From: [Aaron Lowe](#)
To: [Jamey Ayling](#)
Subject: CU-24-00004 White Barn Retreats
Date: Monday, June 17, 2024 3:49:48 PM

Proposed White Barn Retreats at 1360 Westside Rd. I visited the site today for an overview:

- Site Plan -

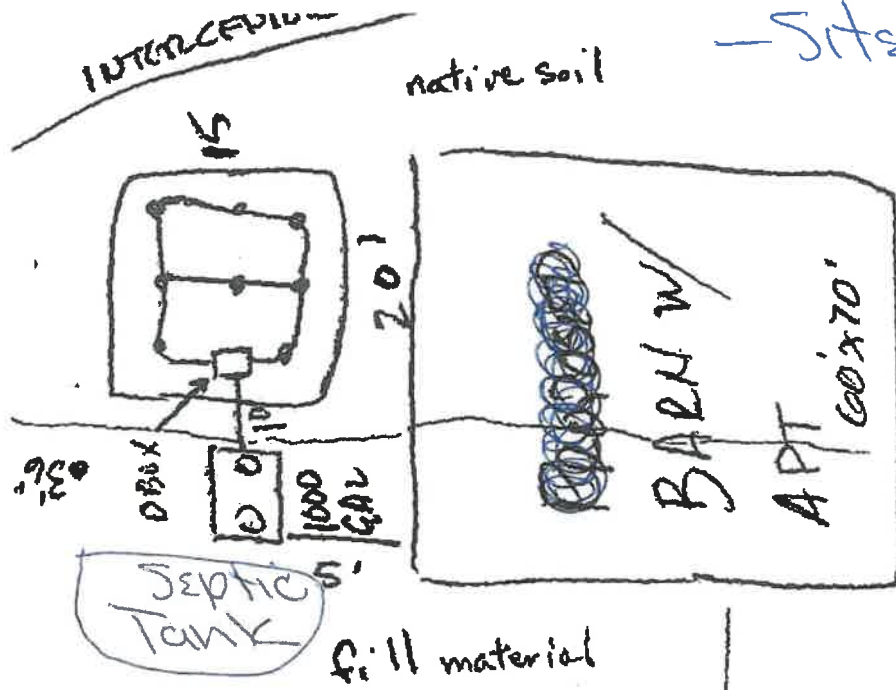
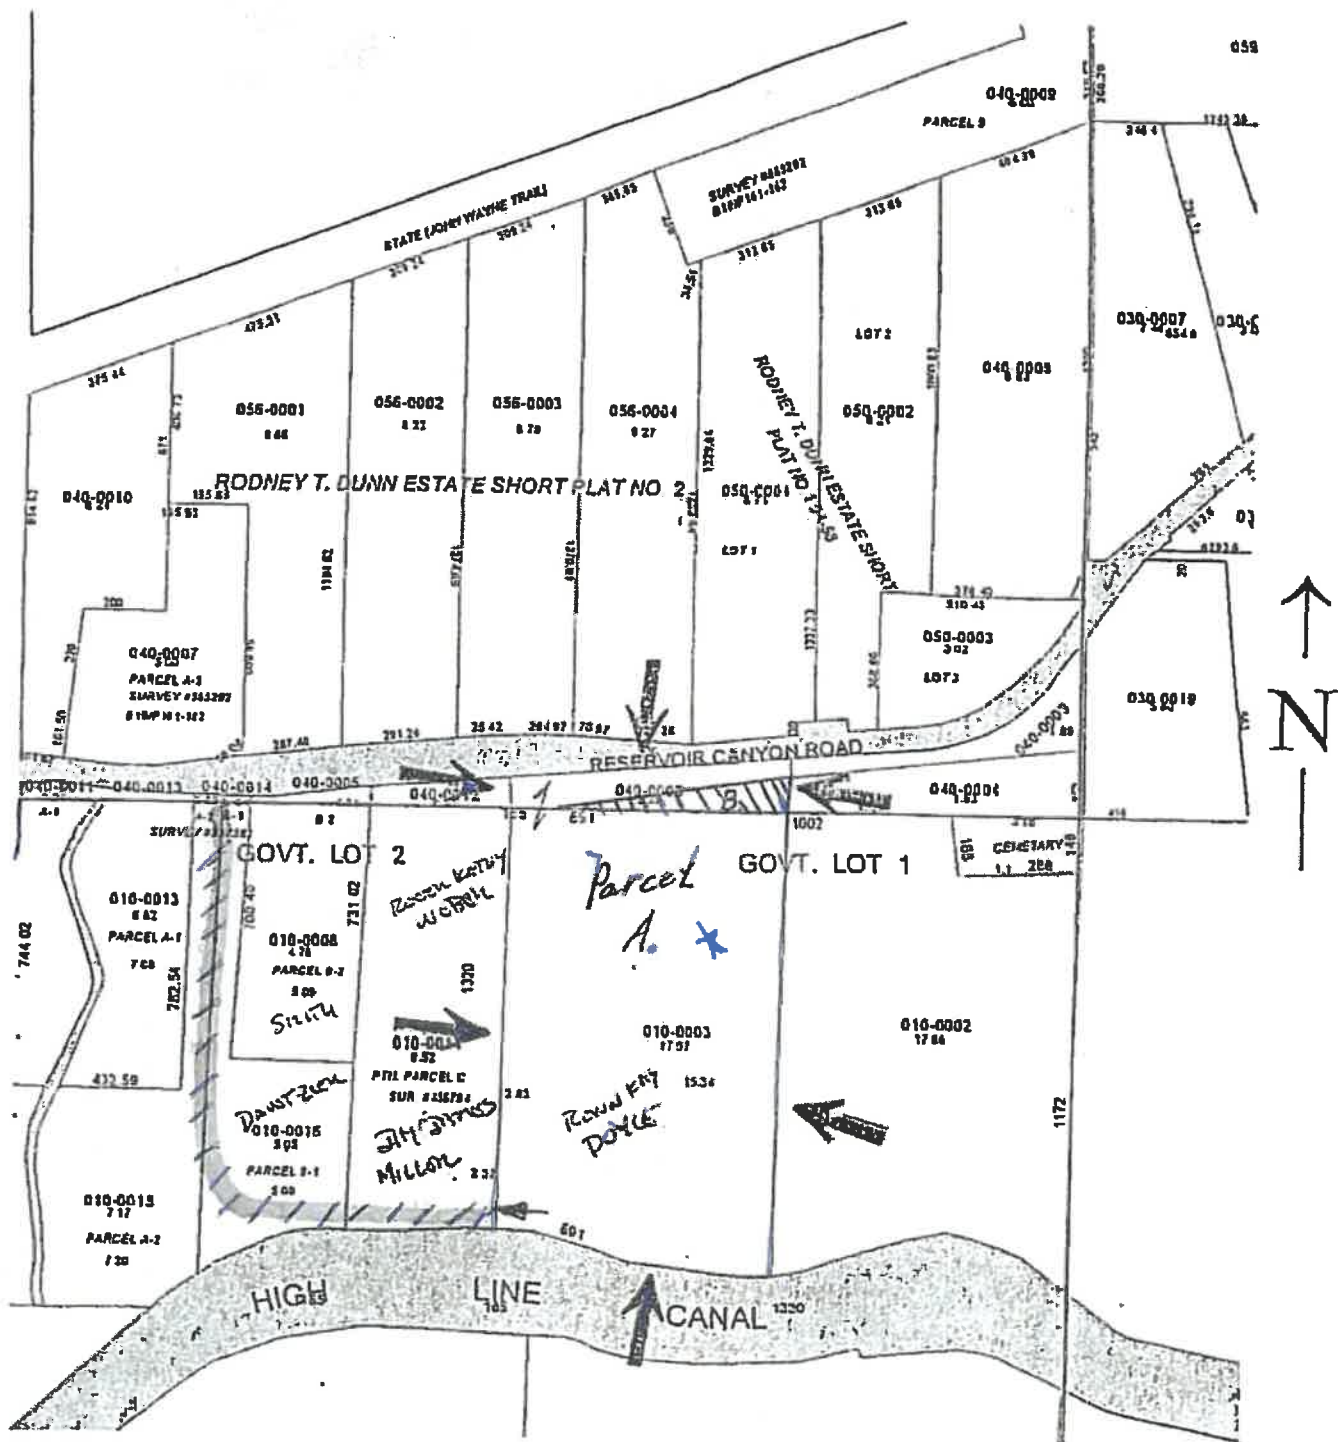
1. The parking area, a grassy field. There will be a potential of a grass fire becoming a multiple vehicle fire. I would suggest we recommend mowing of the field before any event, and placement of fire extinguishers or fire extinguishment devices in that area.
2. There is only one driveway in and out. If we were responding to an incident, we may be delayed by vehicles attempting to leave.
